# CITY OF ALBUQUERQUE

**RE: The Bertin / Meinel Residence**  
**8024 Emerald NW**  
**Grading and Drainage Plans**  
**Engineer's Stamp Date: 6/12/25**  
**Hydrology File: E10D128**  
**Case # HYDR-2025-00213**

C-101

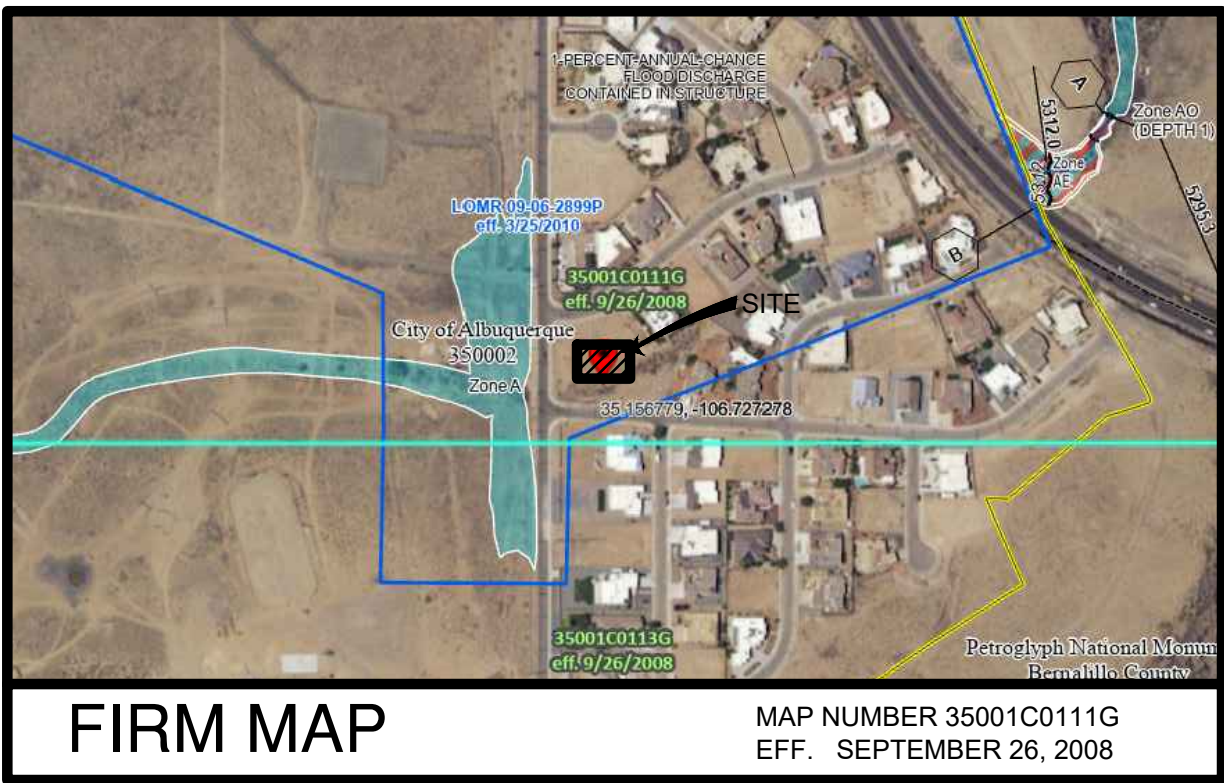
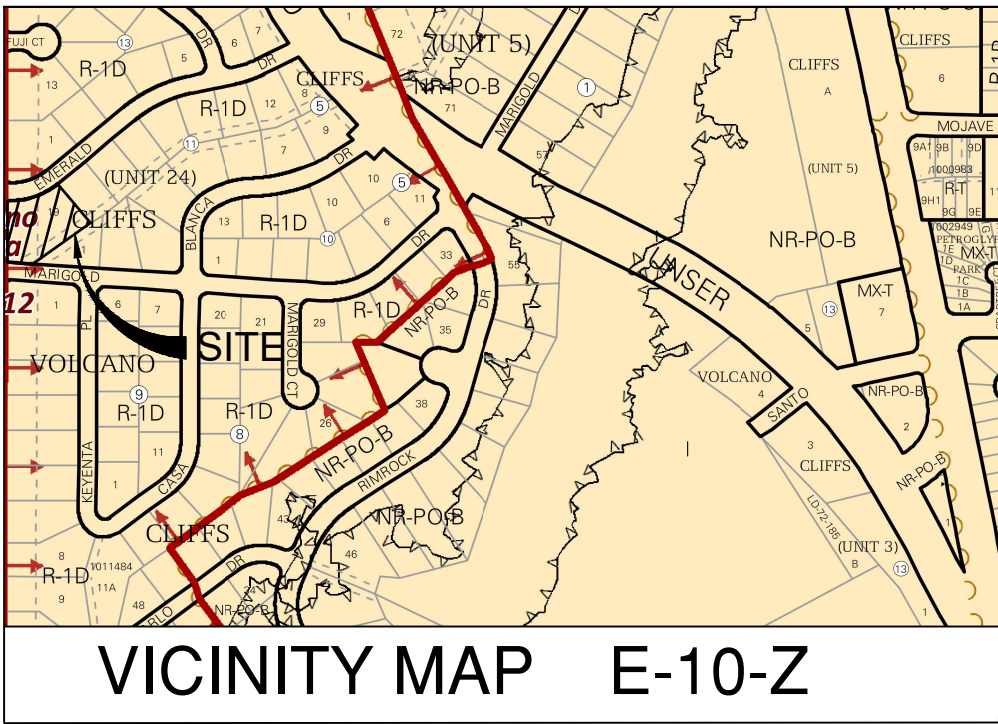
1. Please provide the FIRM Map and floodplain note with effective date.
2. Please show the Special Flood Hazard Area on the plans.
3. A portion of this project is located in a floodplain (A) and a floodplain development permit must be obtained. The permit application must demonstrate zero rise to the base flood elevation, unless a Letter of Map Revision (LOMR) is being prepared. Please contact Rudy Rael, CFM for more information regarding floodplain development permits ([rrael@cabq.gov](mailto:rrael@cabq.gov) or 924-3977).
4. Part of the structure appears to be encroaching into the 100' Power Line Easement. Please verify with the utility that this structure is approved for the location and encroachment.
